Architectural Design Report - Response to Submission

# UNSW Health Translation Hub

This report has been prepared on behalf of UNSW as an addendum to SSD 10822510 for the Health Translation Hub building.

The report has been compiled to respond to the design-related submissions received by the Department of Planning and Environment and Randwick City Council during the public exhibition of the UNSW HTH.

7 June 21 - 3pm
CD305 SCALE: 1 : 2000

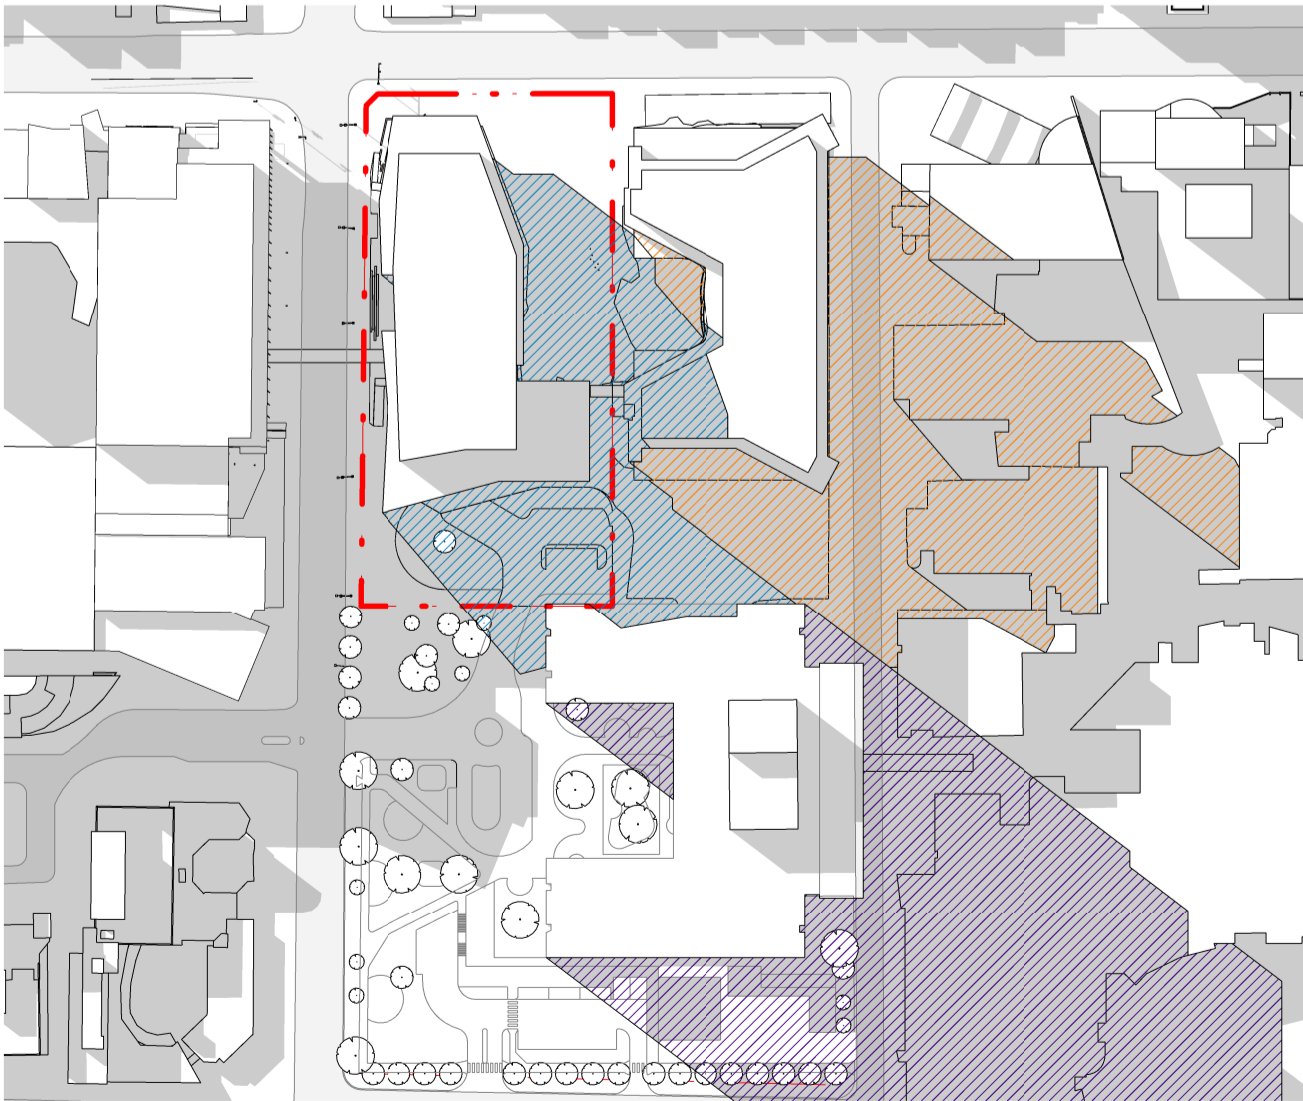
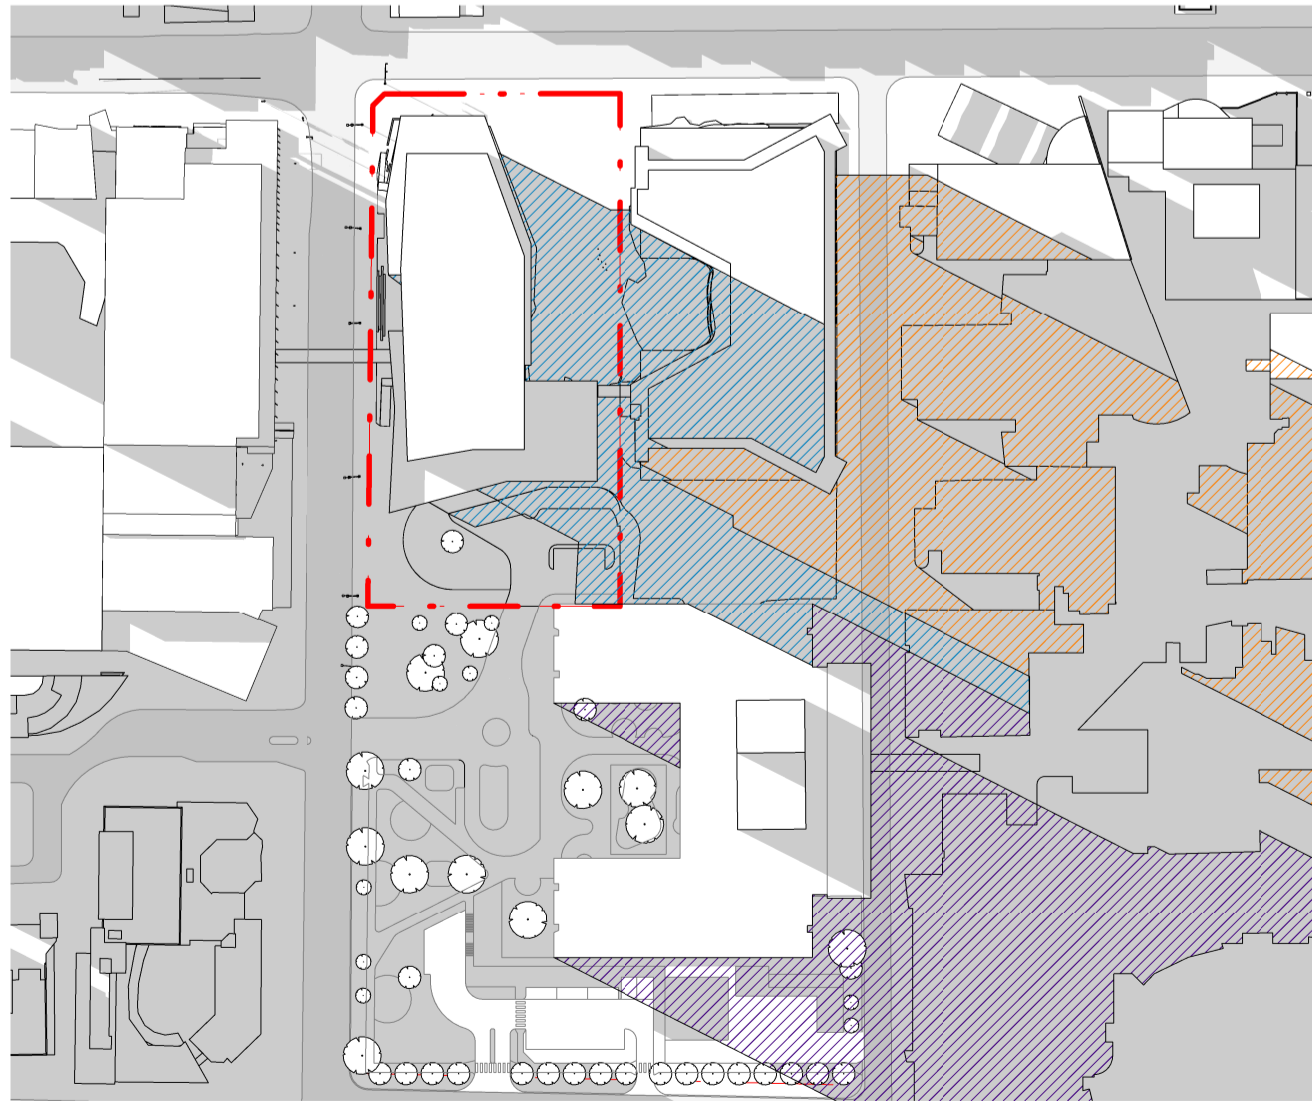
The shadow diagrams provided are limited, addressing only the early morning, midday and late afternoon. Hourly shadow diagrams at the June 21 should be provided to assess solar access and amenity.

Please find the additional shadow diagrams adjacent, and also included in Attachment A.
